KIRKLEES METROPOLITAN COUNCIL INVESTMENT & REGENERATION SERVICE

DELEGATED DECISION TO DETERMINE PLANNING APPLICATIONS

Reference No:	2025/62/90099/W
Site Address:	7, Bradley Grange Gardens, Bradley, Huddersfield, HD2 1QX
Description:	Erection of single and two storey extensions to the side, front and rear and formation of extended access including associated works
Recommending Officer:	Molly Storer

Officer Report.

LOCATION PLAN SCALE 1: 500

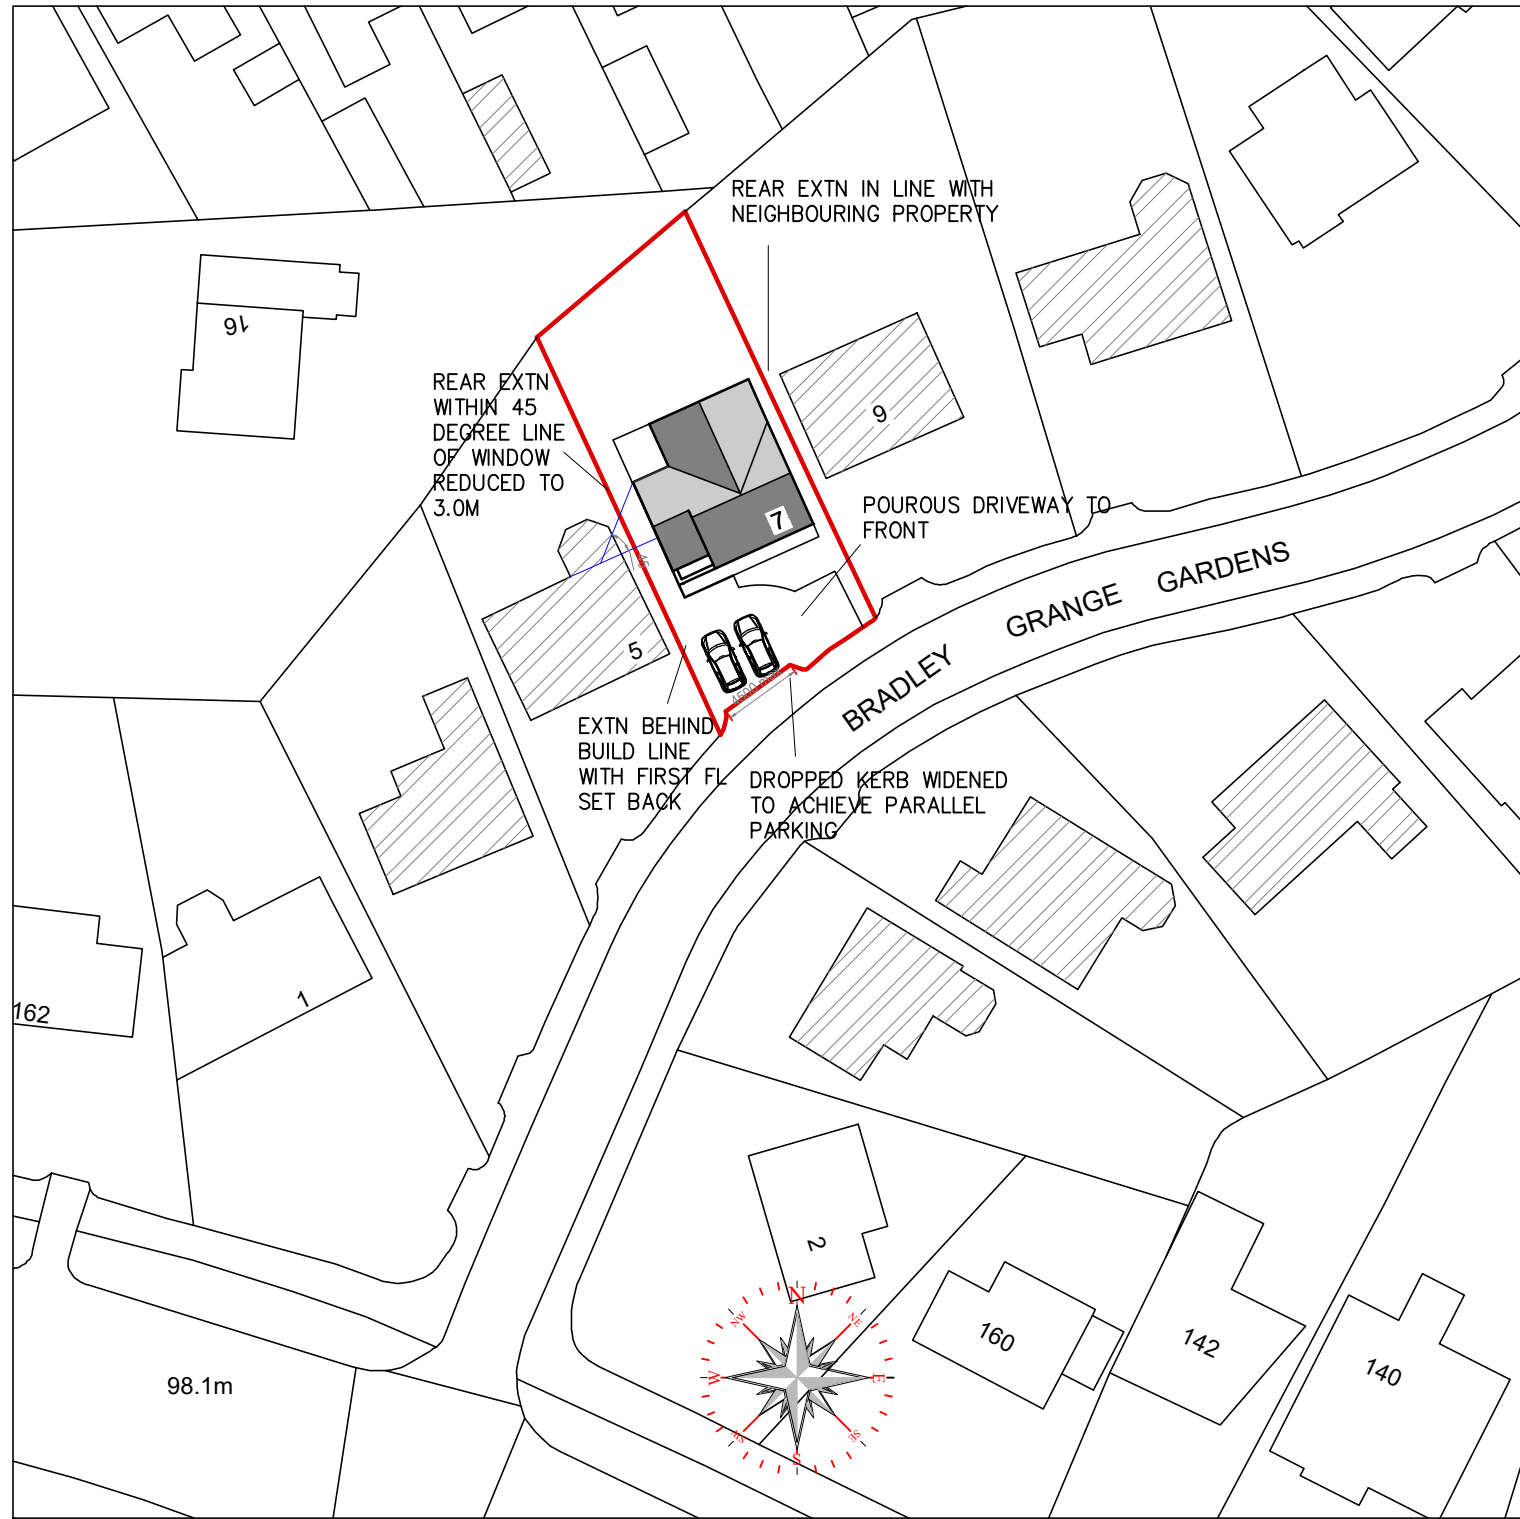
The proposal includes plans to increase the size of the existing driveway, as shown on the location plan submitted as part of the 'Existing Layout' (Ref: PDA23-069-002 Rev D). Given that the driveway is to be extended, and the kerb to be dropped, it is concluded that appropriate levels of off-street parking would be provided at 7 Bradley Grange Gardens.

5. Prior to the development being brought into use, the approved vehicle parking areas shall be surfaced and drained in accordance with the

Communities and Local Government; and Environment Agencies 'Guidance on the permeable surfacing of front gardens (parking areas)' published 13th May 2009 (ISBN 9781409804864) as amended or superseded; and thereafter retained throughout the lifetime of the development.
